From: Laura Gibbons
Sent: 23 June 2020 13:56
To: Planning.Responses <Planning.Responses@arun.gov.uk>
Cc: Simon Davis <Simon.Davis@arun.gov.uk>
Subject: N of Summer Lane P/35/20/DOC & P/37/20/DOC

We have the following comments regarding the revised surface water drainage details submitted for P/35/20/DOC and P/37/DOC.

Headwall SW-13

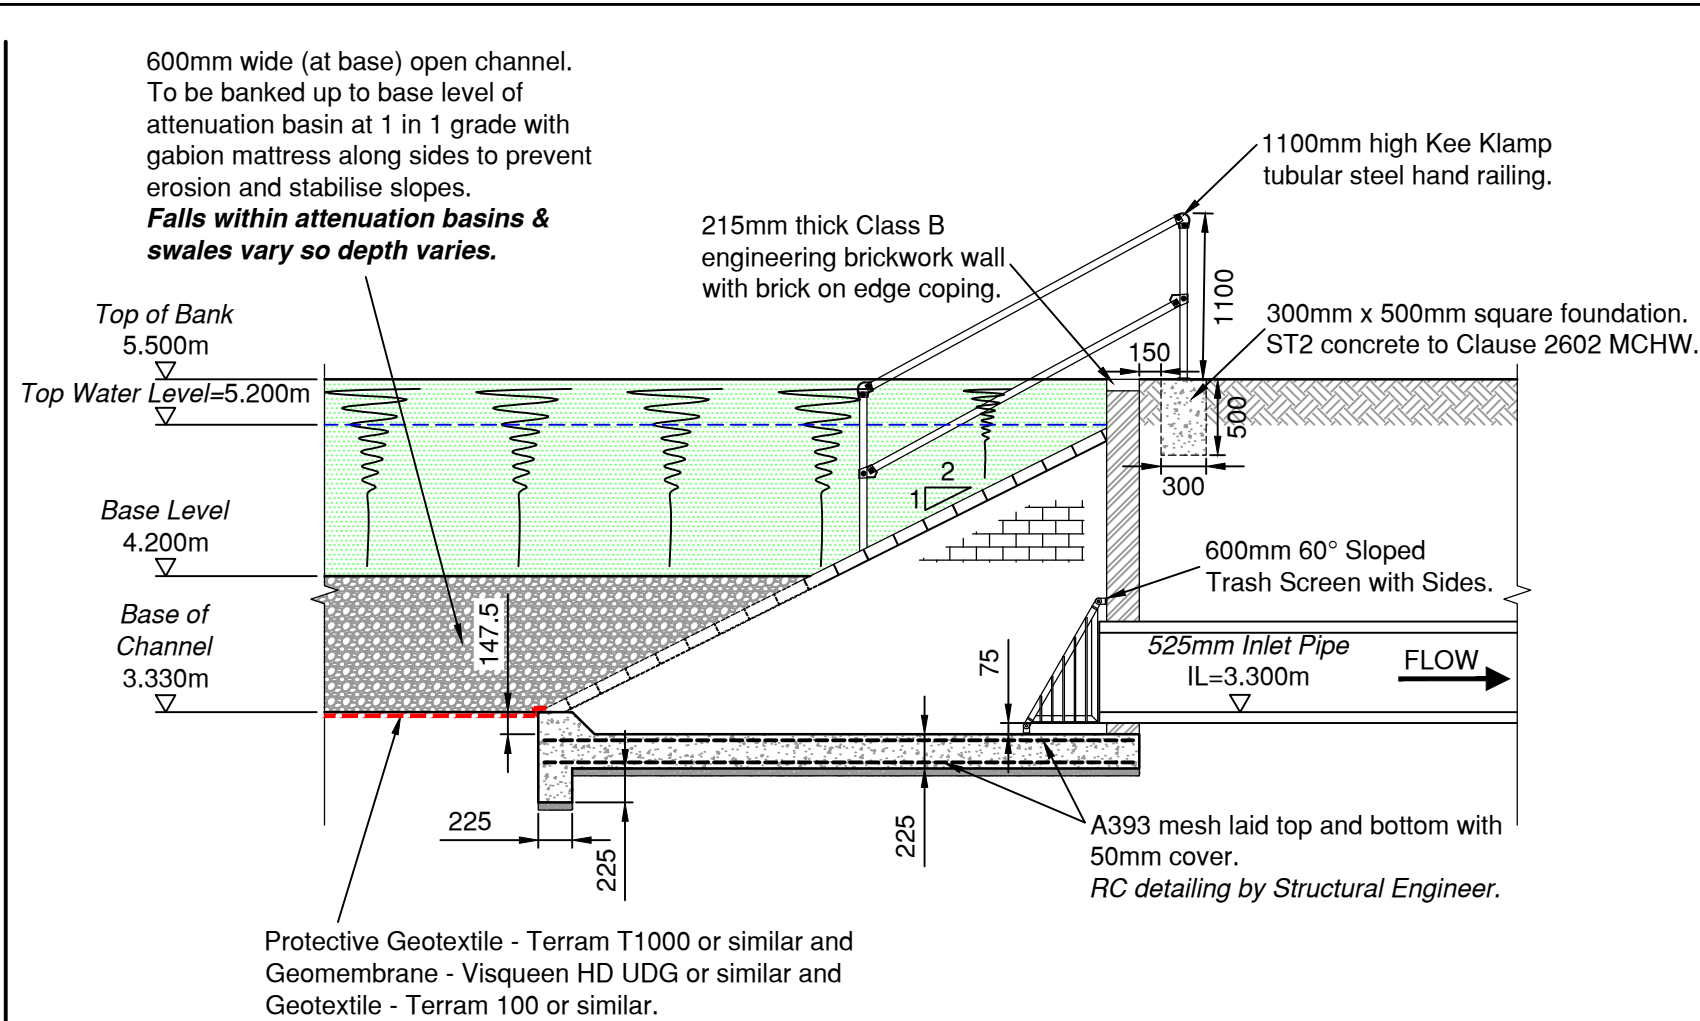
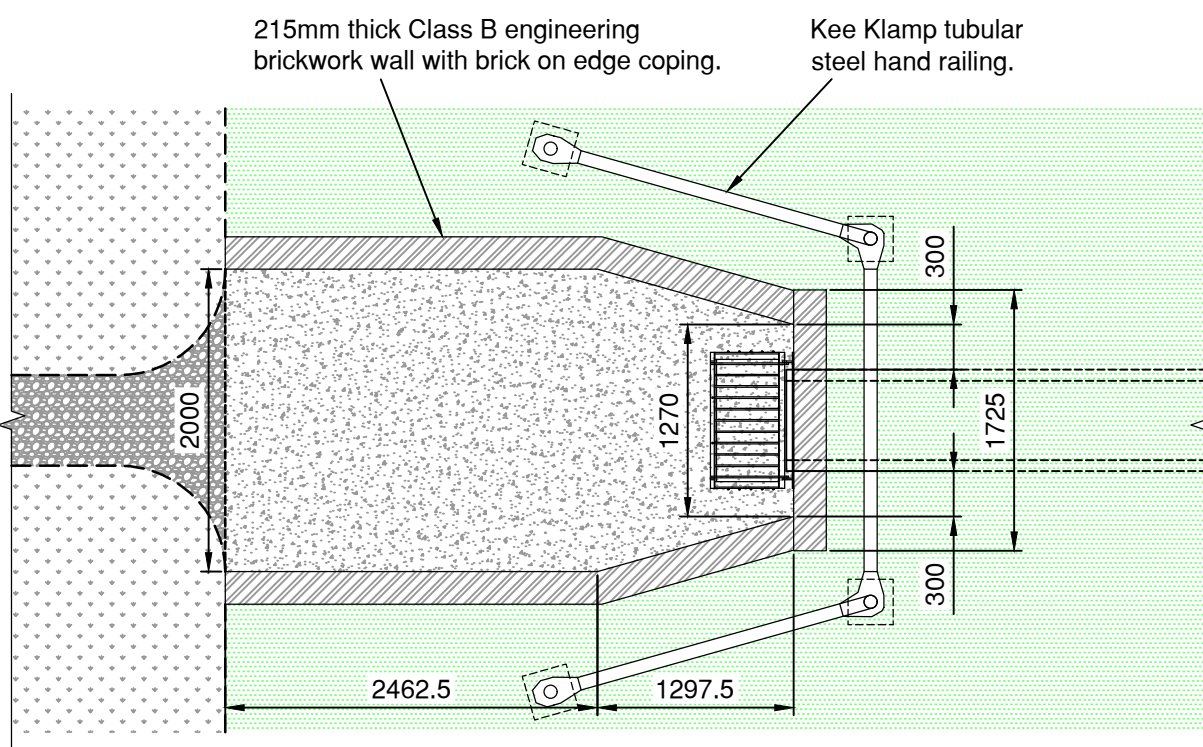
9. All headwall grilles to be cranked as opposed to be flat or just sloped faced. **Headwalls SW-4, SW-5, SW-9, SW-13, SW-29 and SW-32 updated to cranked grilles. Headwall SW-9 cross-section grille not shown (layer not visible?), please ensure this is visible on drawings. Please remove note to Sewers for Adoption, please add construction detail showing typical grille, ensuring that bar spacing, materials, point of lock are shown.**

Headwall SW-32

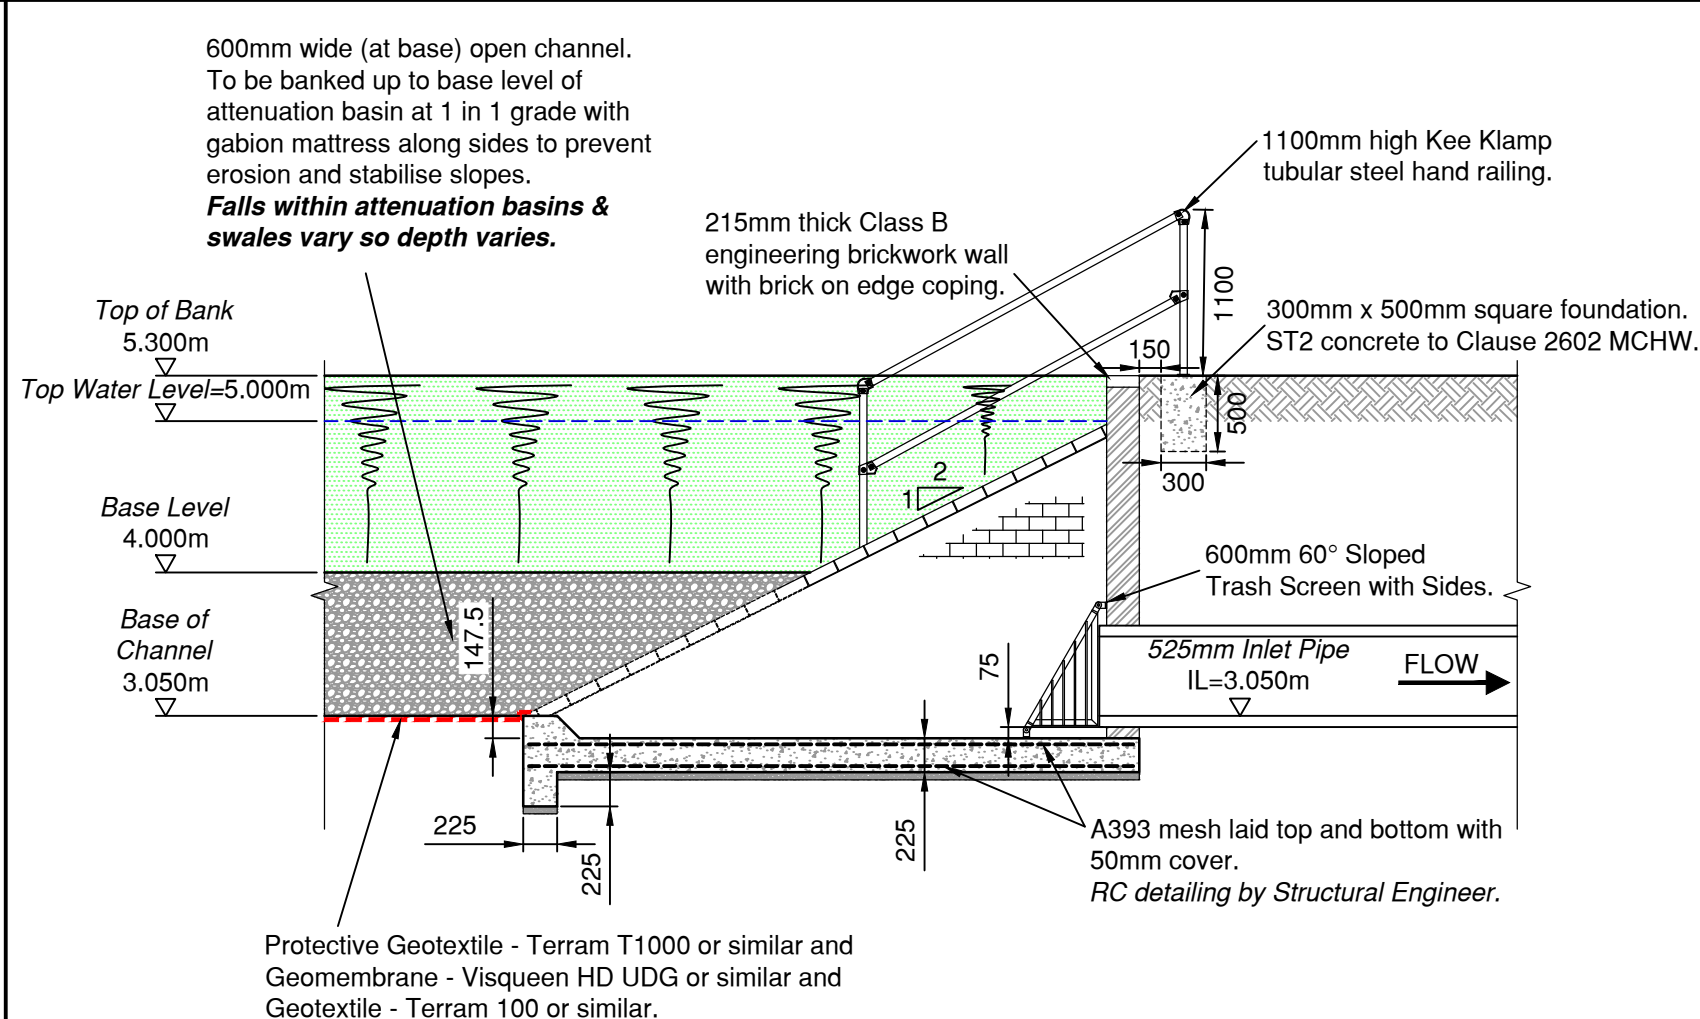
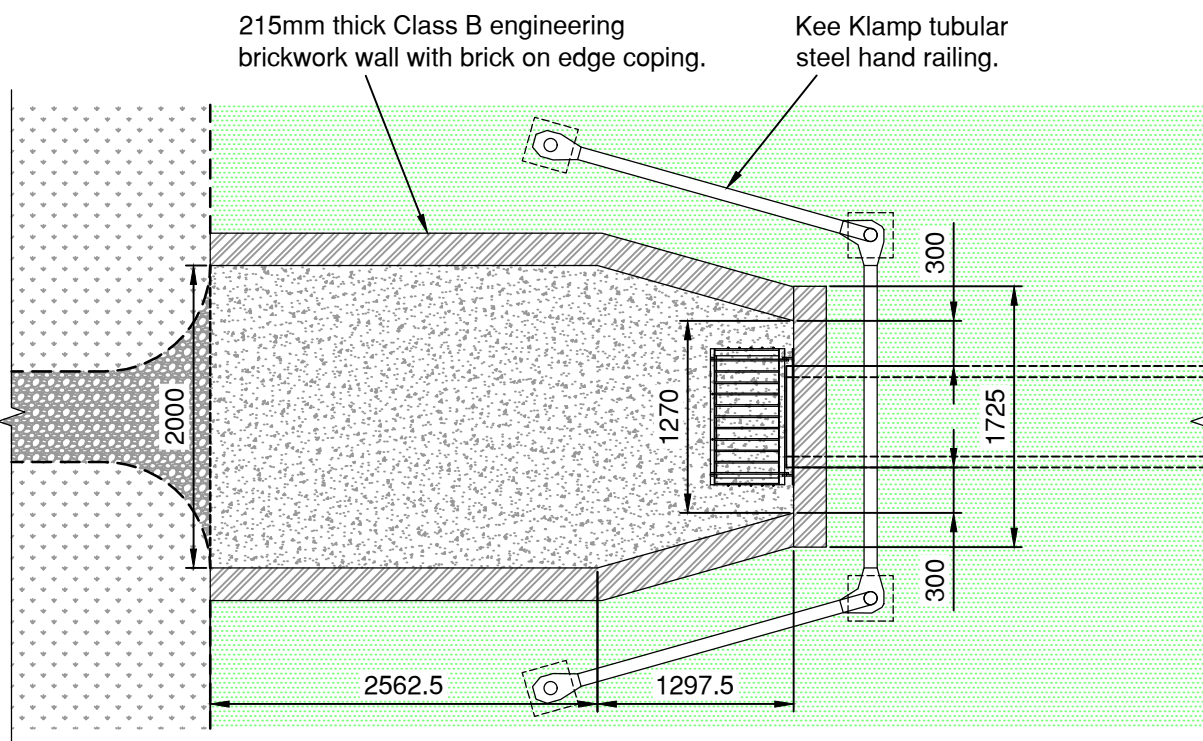
17. Incoming pipes at headwalls SW-4, SW-5 and SW-32 — increase freeboard between pipe inverts and basin/swale bed. *The base of the pipe work connects to the drain bed level, which is specifically deepened to accommodate the incoming pipework levels and eventually connect onto the downstream watercourse. This is a similar arrangement to the main drainage channel running through the swale associated with headwalls SW9 and Sw13. Understand the difficulties here, however minimum of 150mm above pipe inverts and base of swale should be provided.*

44. Headwall SW-32 – investigate connecting the 450mm and 225mm pipes together via a manhole before connection to the headwall or alter upstream arrangement to ensure both pipes connect to headwall in parallel. — *Already actioned as part of subsequent update*

Headwall SW-14

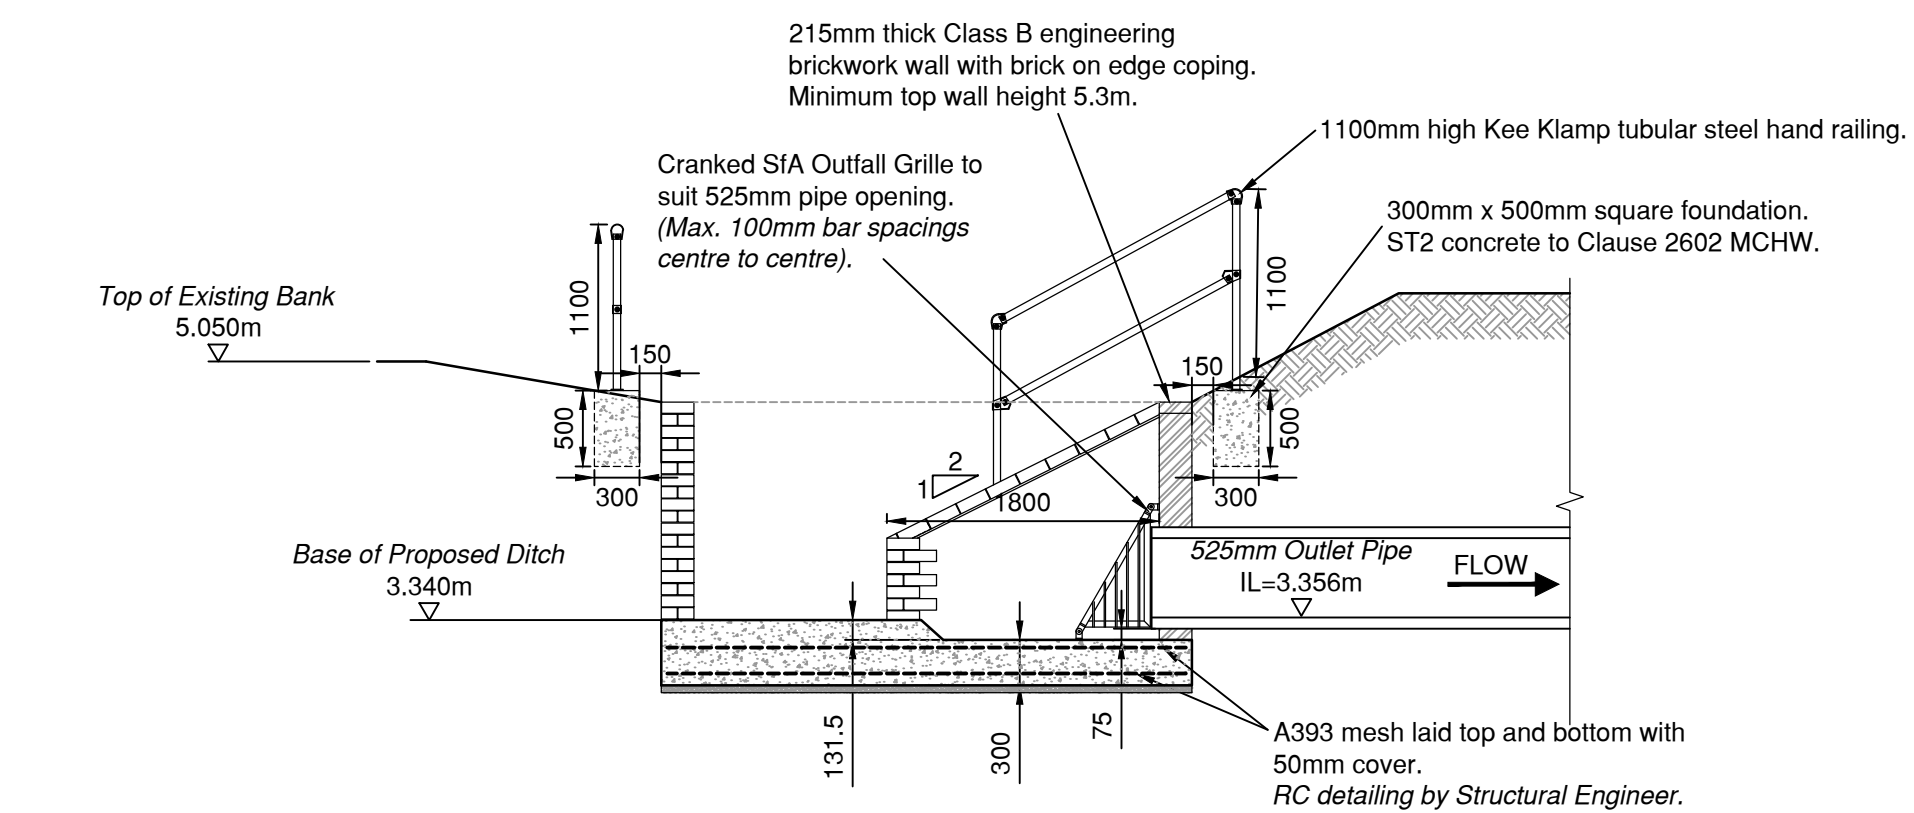
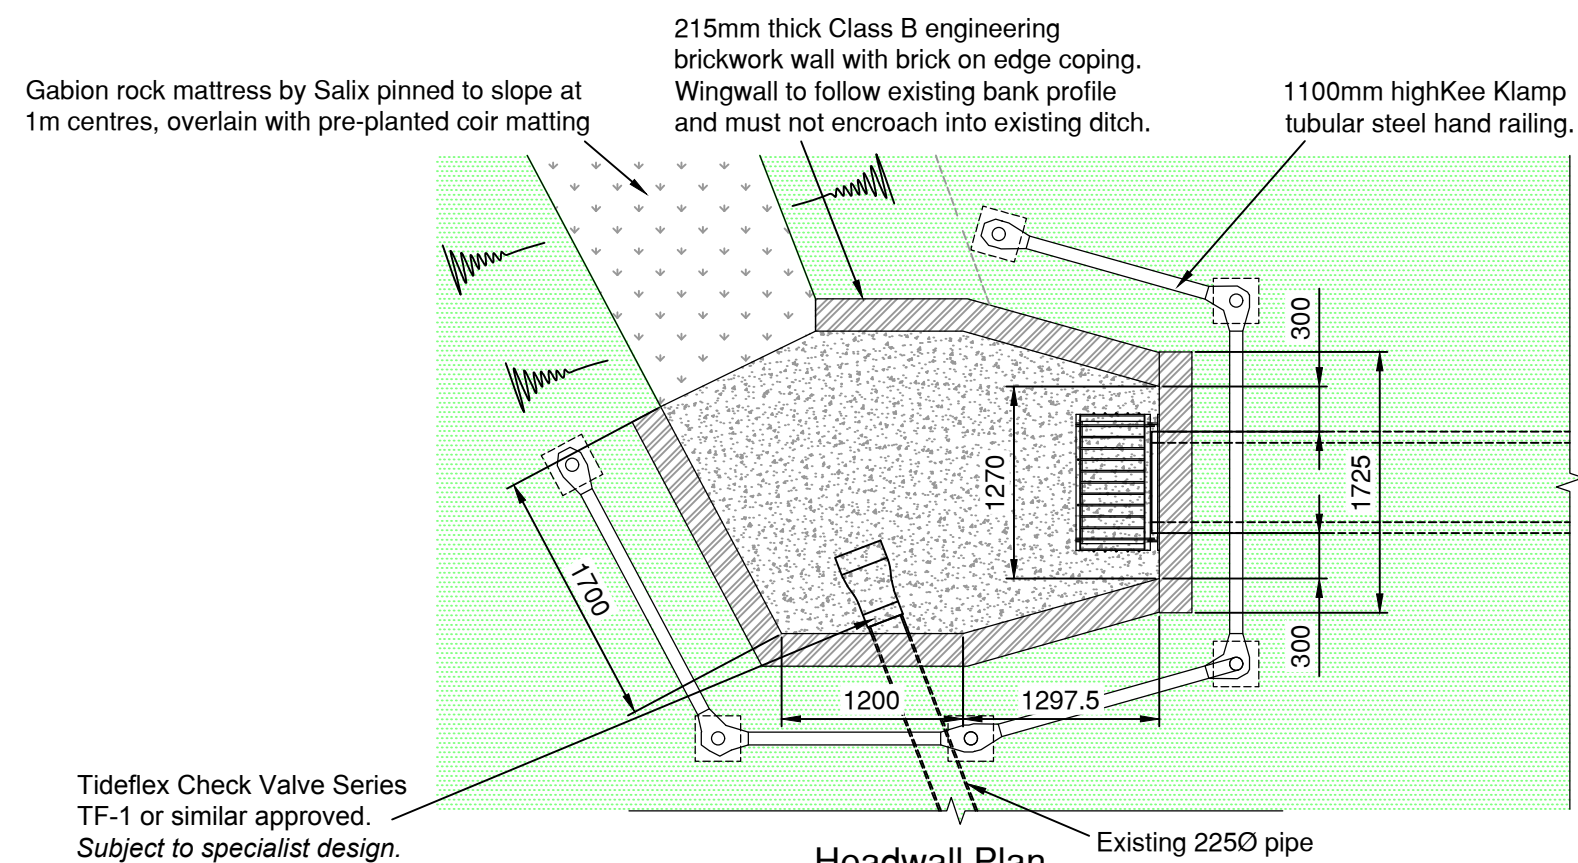
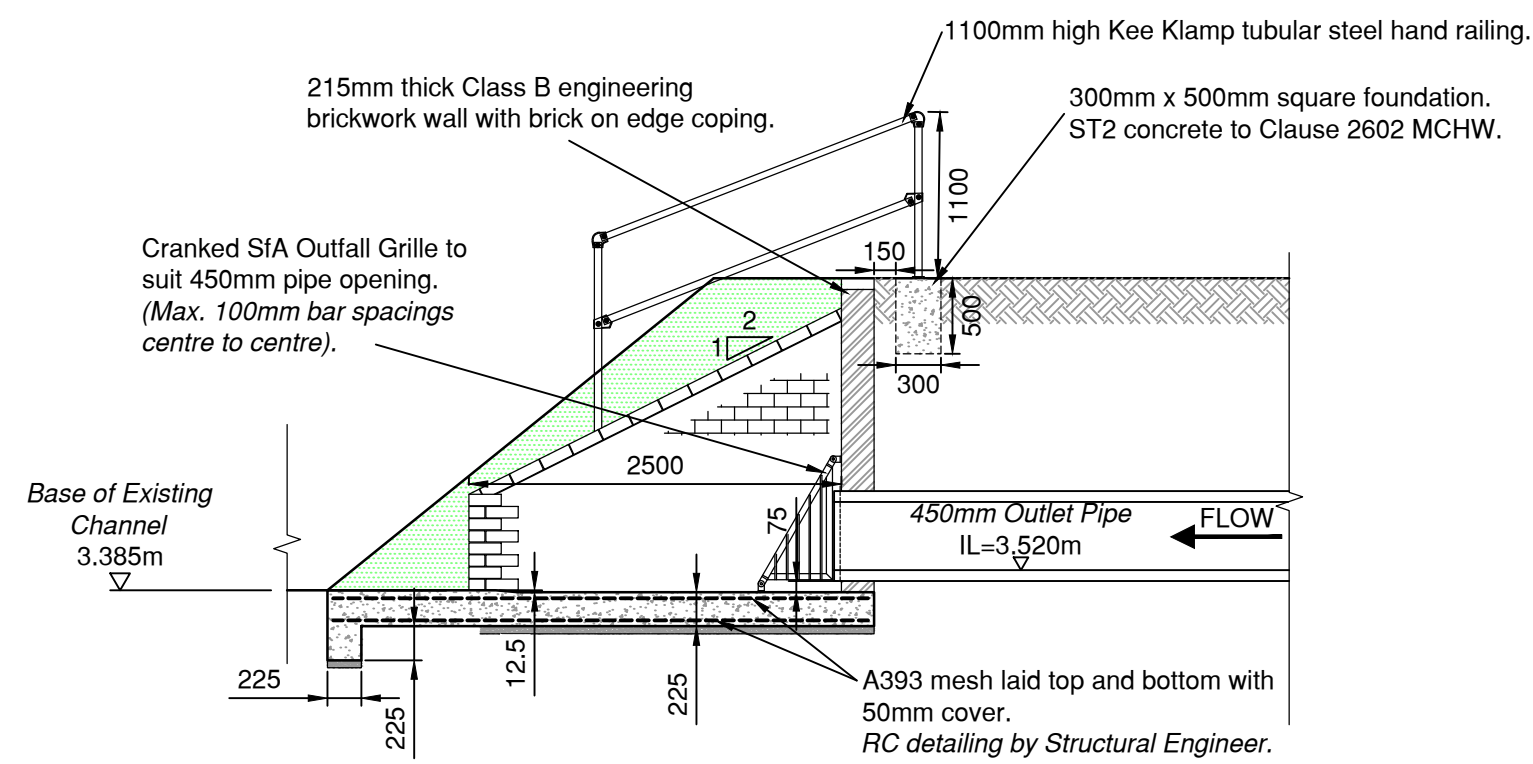
10. Provide construction detail for headwall SW-14. **Per OWC – will be provide a copy of these along with this response as well. Unclear where this is included in details, please provide.**

Headwall SW-15

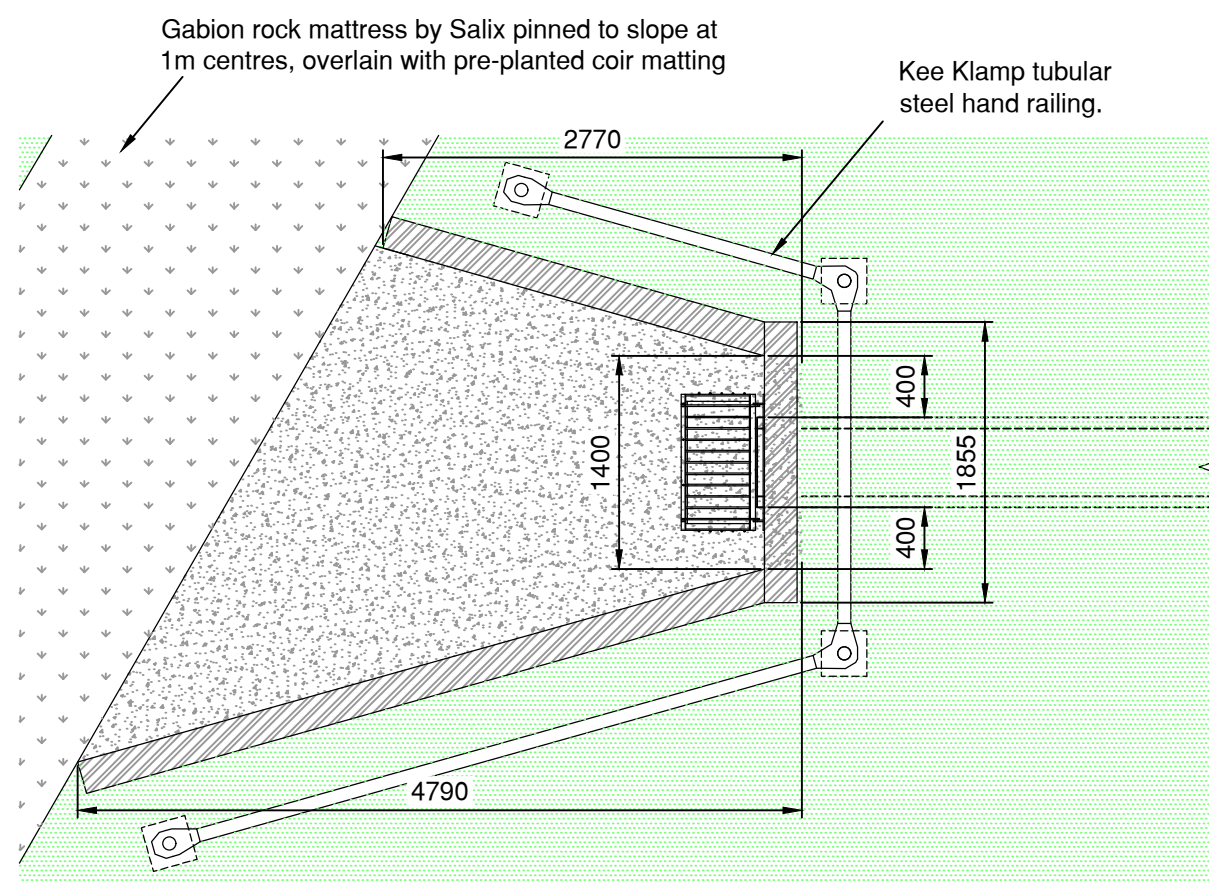
40. SW-16 to Headwall – improve gradient to min. 1 in 400, ensuring as much freeboard as possible between pipe invert and ditch bed. Longitudinal section doesn't appear to show the SW-16 to SW-15 arrangement as per the layout plan ie. SW-15 is a headwall not a manhole. Per OWC – will be provide a copy of these along with this response as well
